Recommendation Report for Planning Permission

REF NO: FG/23/12/

LOCATION: 51 Langbury Lane
Ferring

PROPOSAL: Proposed single storey rear extension.

Proposed side elevation. Scale 1:100

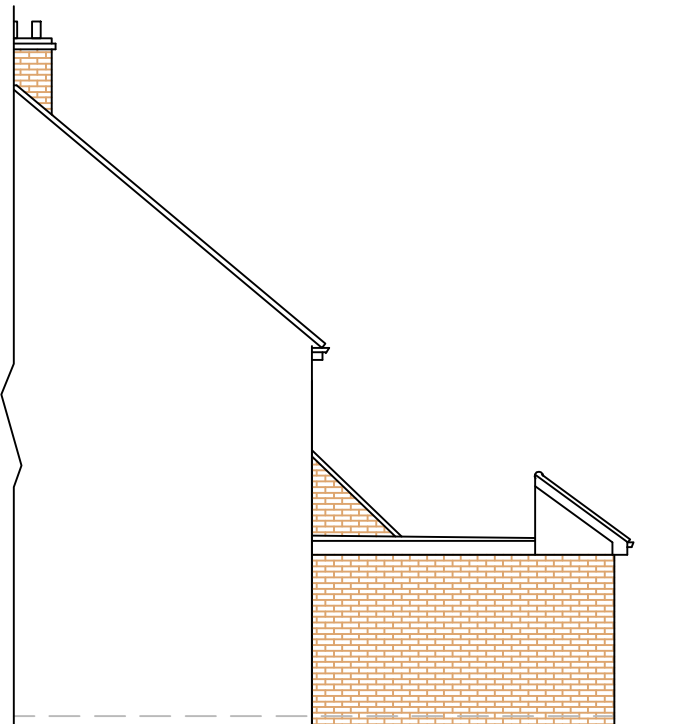
On the northern side it is noted that it is likely that the proposed extension will conflict with the 45 degree rule adopted by the Council as a tool in assessing the impact of extensions on the residential amenities of neighbouring properties. However, the amount of development that could be erected to the rear of the property as permitted development would be comparable to that proposed and also exceed this rule.

However, given the single storey nature of the proposed extension, combined with the 2.5 metre high flat roof and existing boundary screening of approximately 1.8 metres in height, it is not considered that the extension would detrimentally harm the residential amenity of the occupiers of the neighbouring property by way of overbearing affect, harmful overshadowing, overlooking or loss of privacy.

Proposed Ground Floor Plan. Scale 1:50

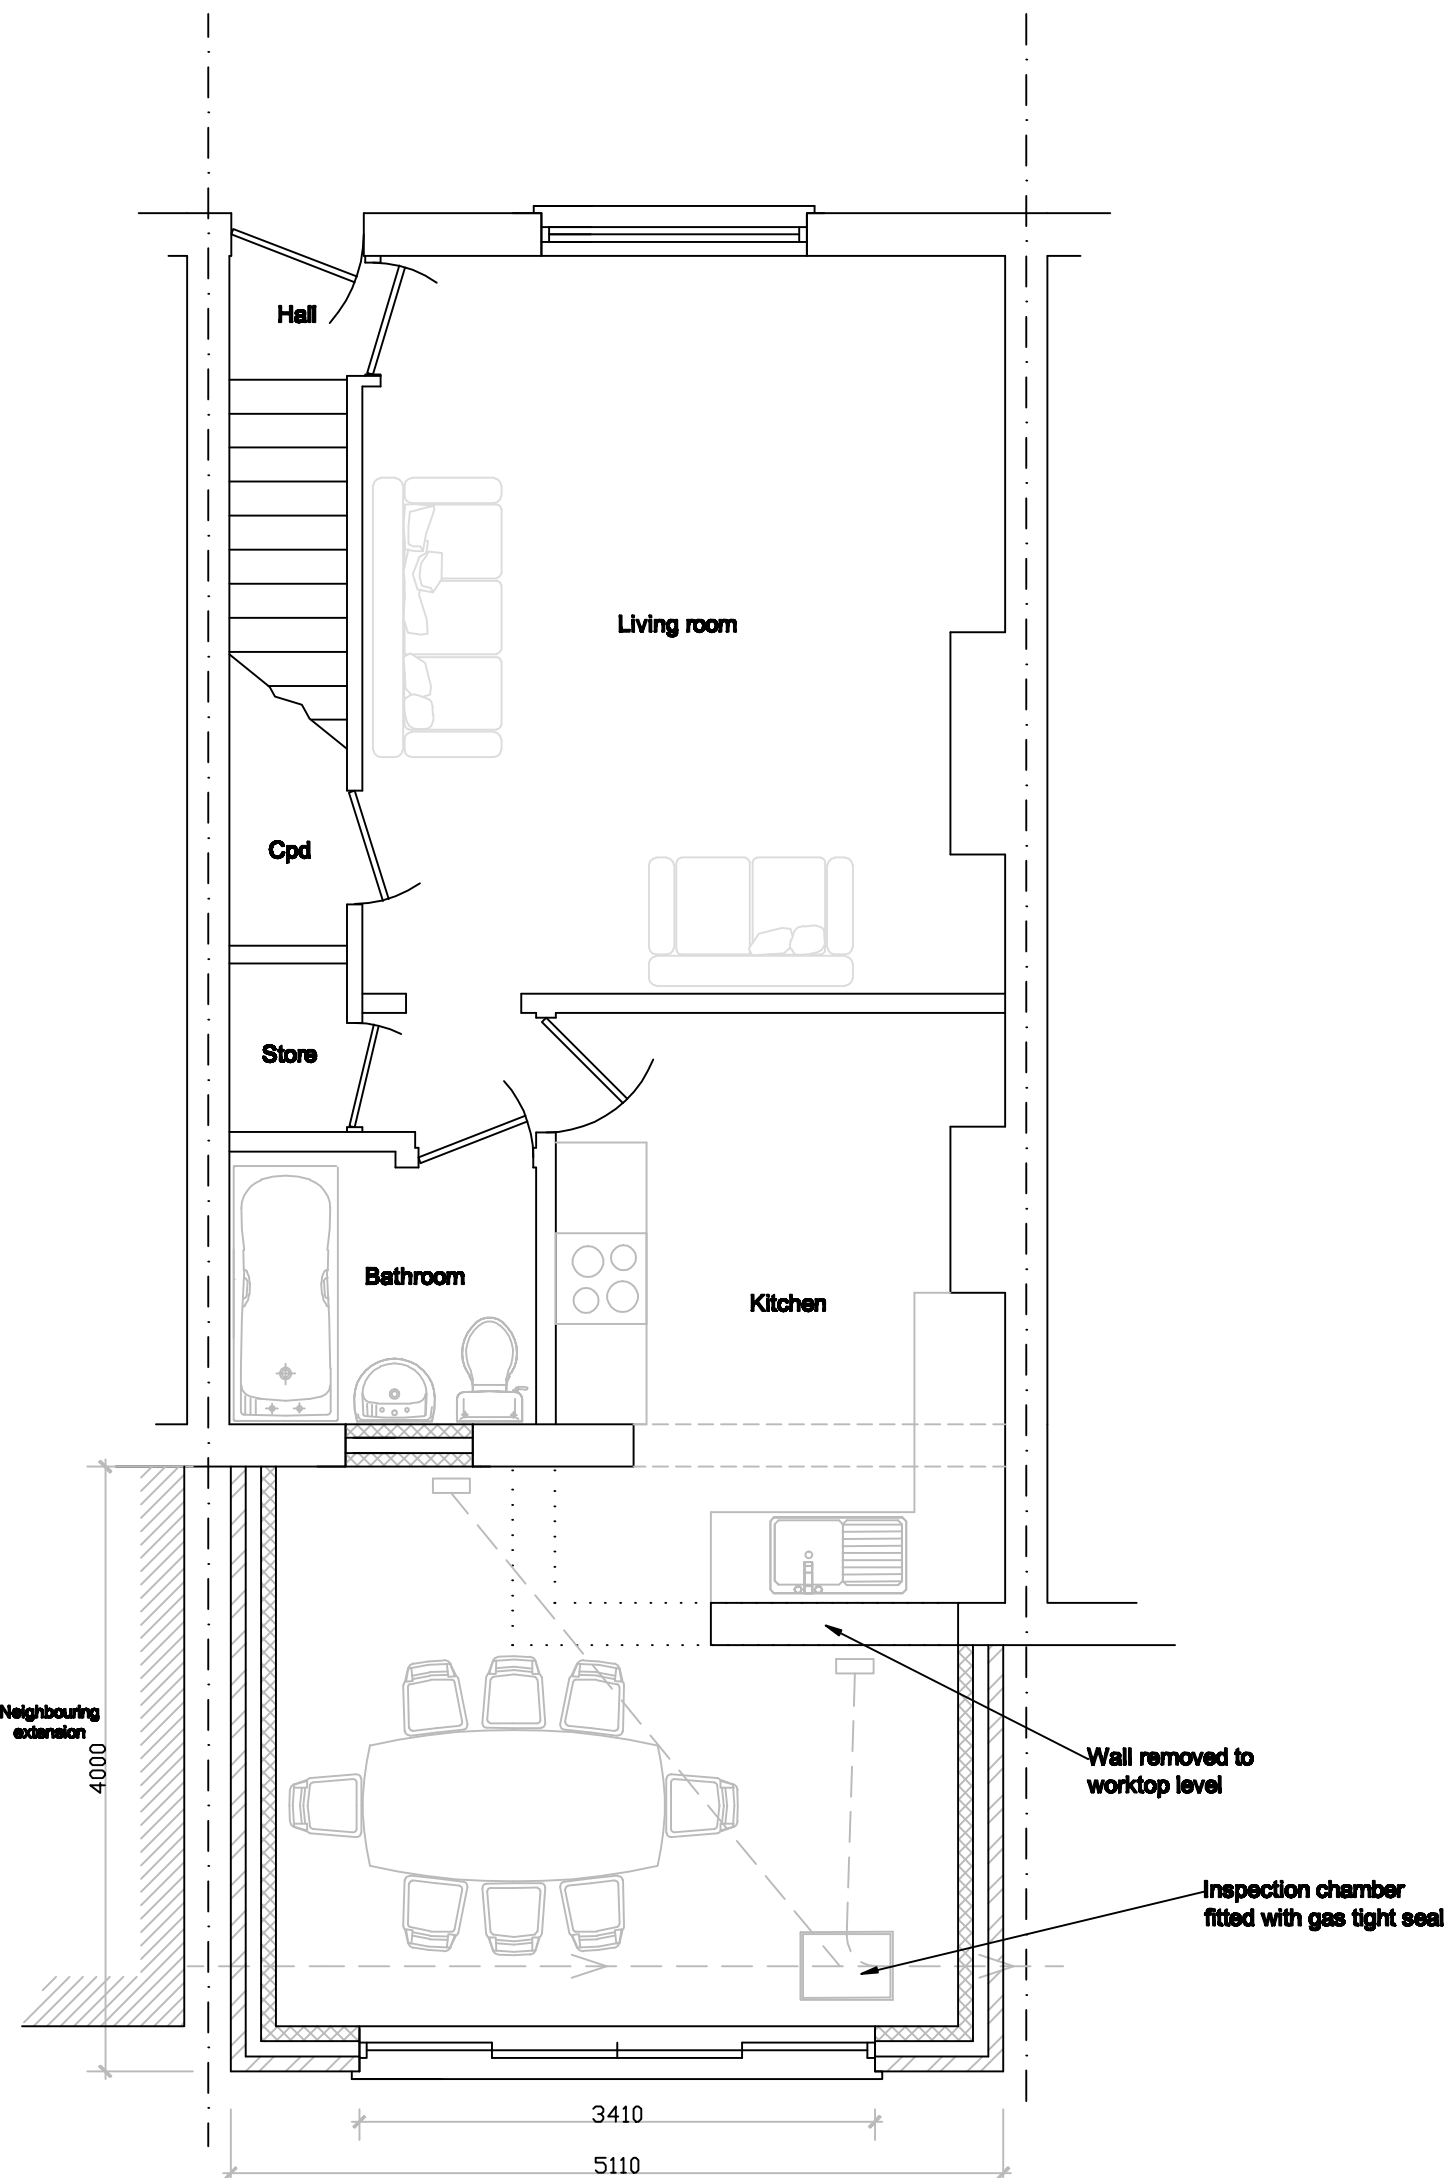
The proposed single storey extension is within the built up area where development is acceptable in principle, subject to normal development control criteria. The proposal is for a single storey ground floor extension. It will extend the existing kitchen outwards and provide a dining room of some 18.5 square metres extra internal floorspace.

The proposed single storey extension is not considered to result in any significant loss of residential amenity. The proposed extension will mirror a similar extension to the rear of 53 Langbury Lane and will not significantly harm the property to the south 49 Langbury Lane. There are no proposed windows on the side elevations and therefore there are no effects on neighbours by potential increase in overlooking. The new glazed double doors to the rear will not significantly affect residential amenity as it is replacing an existing large window and the existing back to back distances are large enough to maintain sufficient privacy.
